Your Ref: OWPC4691
Our Ref: LU/328/14/PL 21-10-2014
Please ask for:
Mr D Sullivan

Construction of side extension to industrial unit
Unit 10 Martello Enterprise Centre Courtwick Lane Wick Littlehampton

Thank you for your internet representation made on 7th January 2015 which has been recorded as '**an objection**' with the comments as follows:

Proposed Extension for RJH Construction
Unit 10 Martello Business Centre, Courtwick Lane, Littlehampton
- AS EXISTING + Proposed Roof Plan

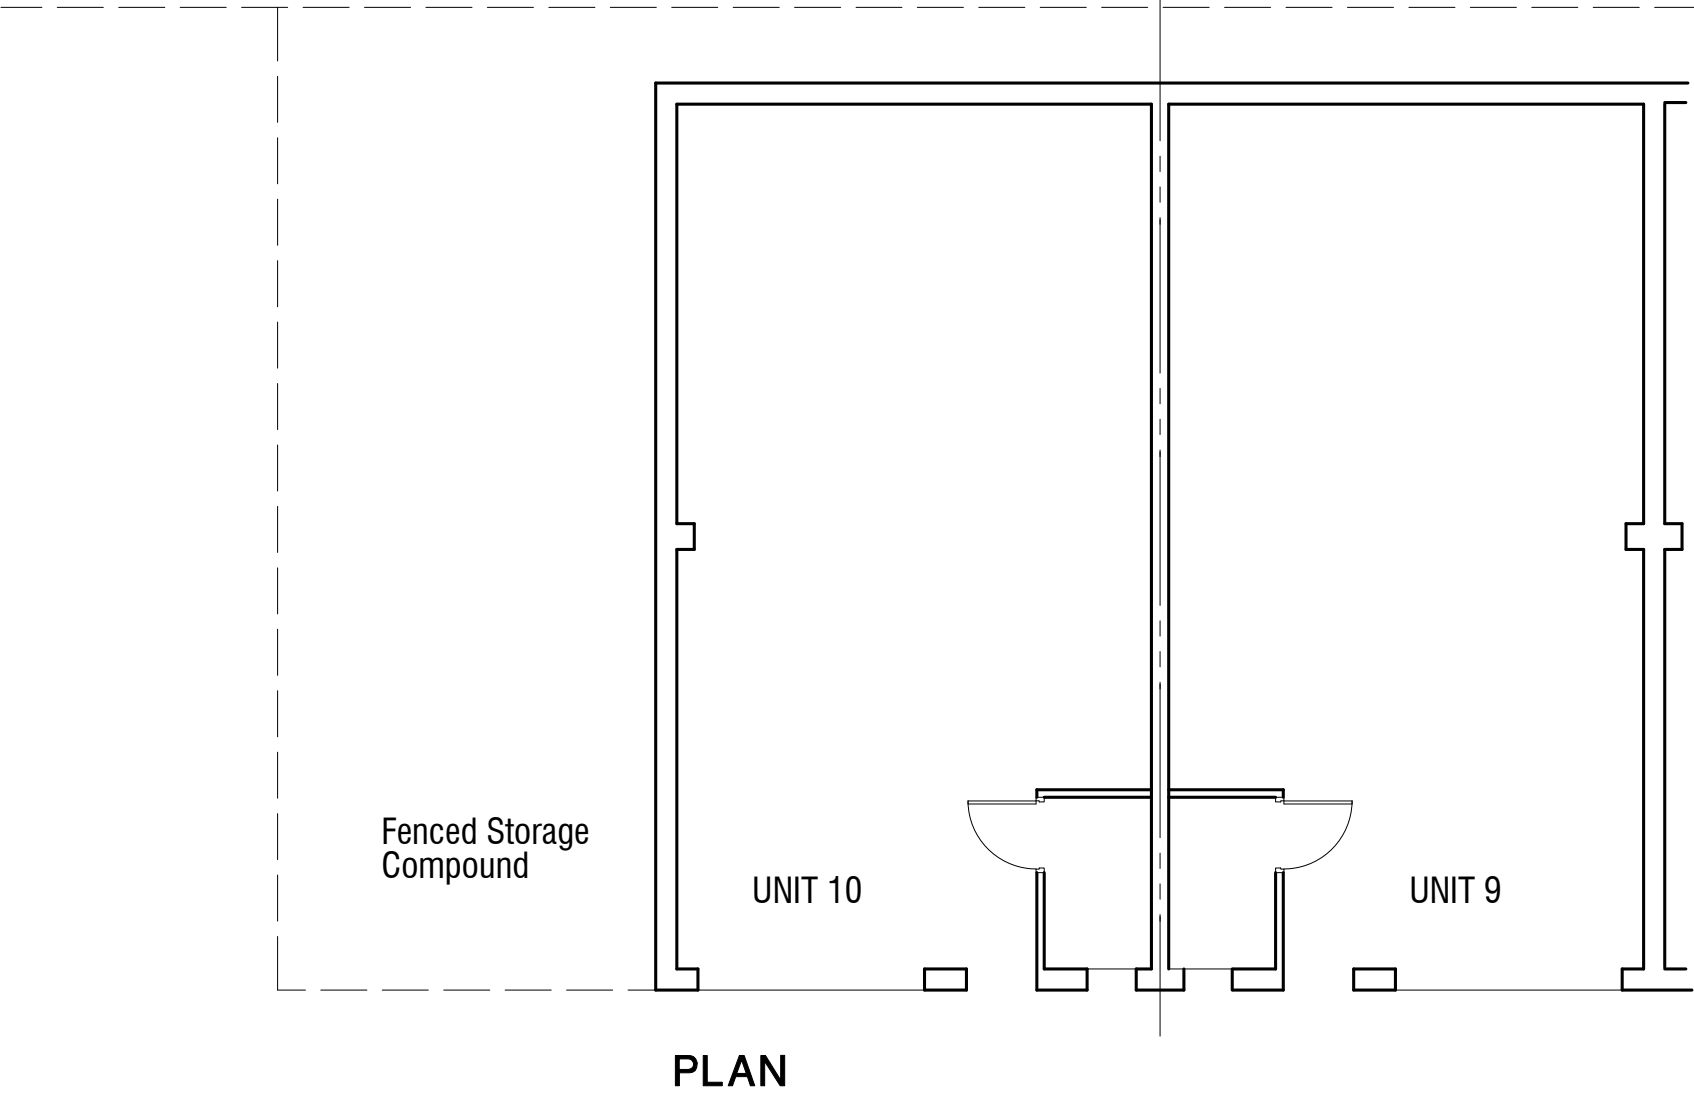
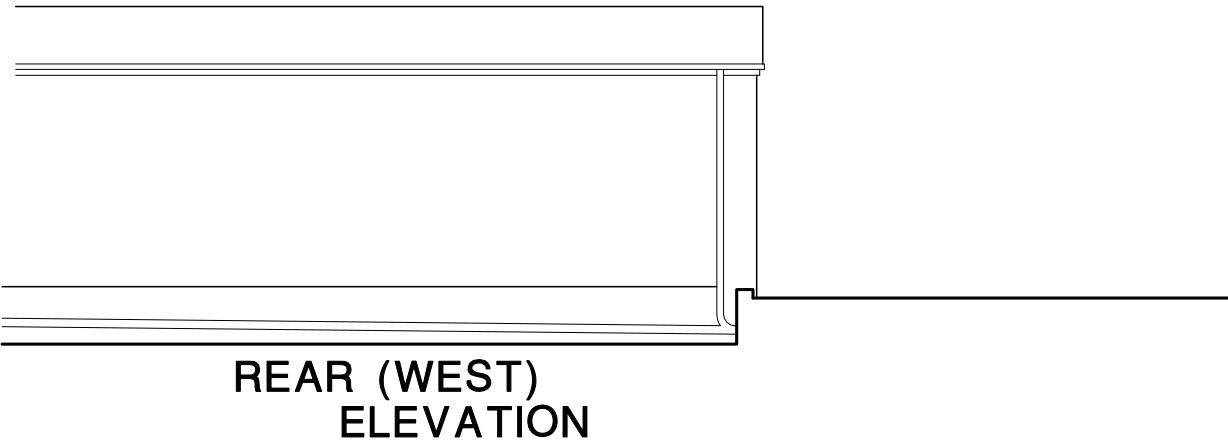
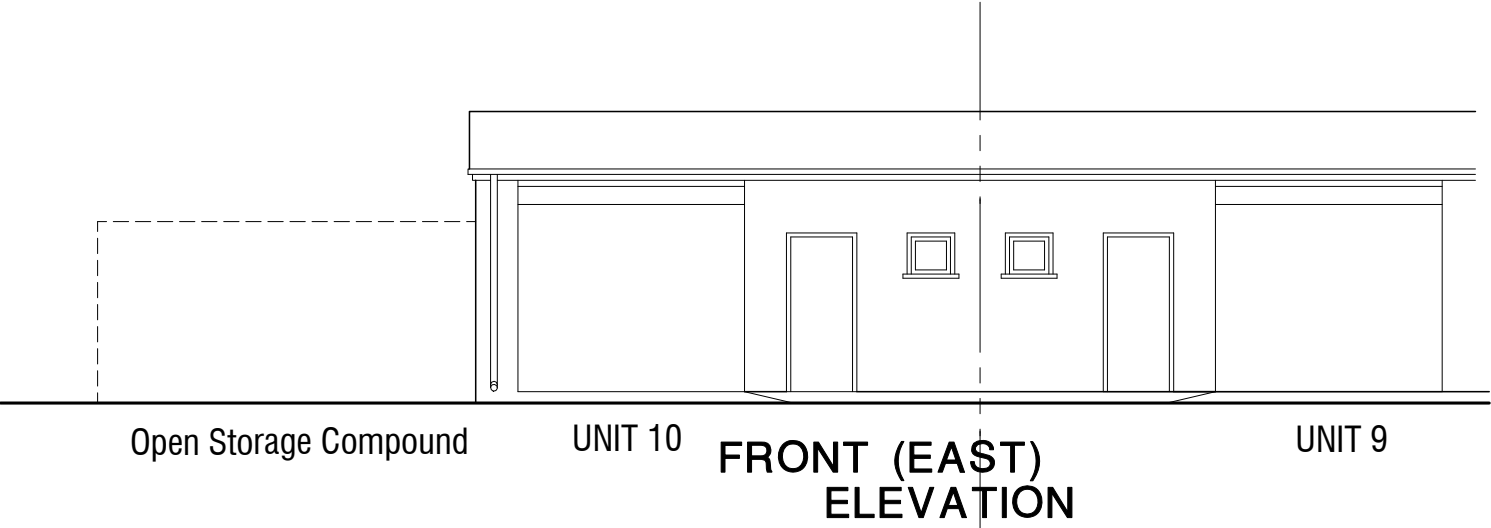
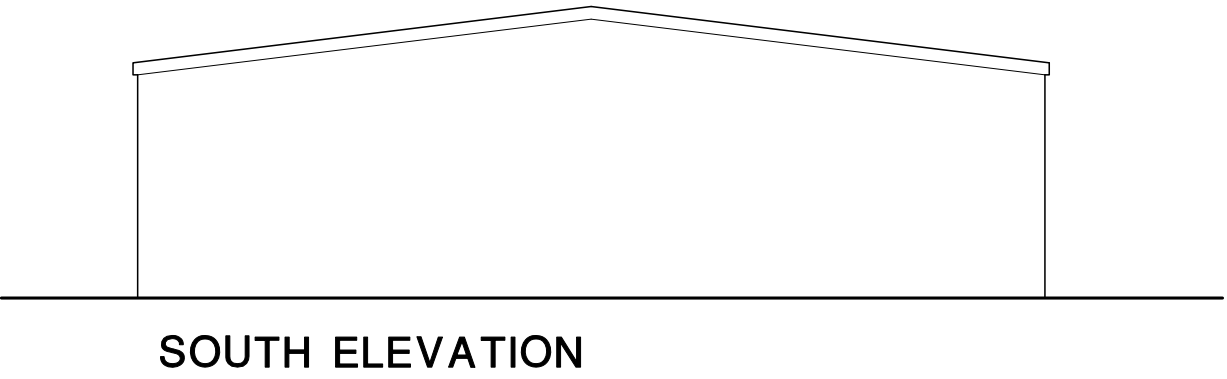
The plans submitted regarding the proposed extension to Unit 10 detail the creation of an additional parking space in line with the left hand corner of the building "P3" and what appears to be the boundary of the unit shown in red. Firstly we wish to comment that the area within the red line includes not only the freehold property but also common land belonging to the Martello Enterprise Centre Management Committee "MECMC". Mediwin Ltd owns the freehold property Units 11-13 and 15 within the Martello Enterprise Centre. Unit 11 is accessed from the common land that includes the area shown in red on the plans running parallel with Unit 10 from the existing car parking space allocated to Unit 10 "P1" and the proposed parking space "P3". Any regular or long-term use of this common land would seriously affect our ability to access Unit 11 which is in constant use accepting regular deliveries of pallets of goods. A forklift is required for the loading and unloading process and any restriction of the space would make the safe operation of the forklift impossible. Access to the three parking spaces adjacent to "P1" which are allocated to Unit 11 would also be severely compromised. Mediwin Ltd therefore must object to the plans as submitted.
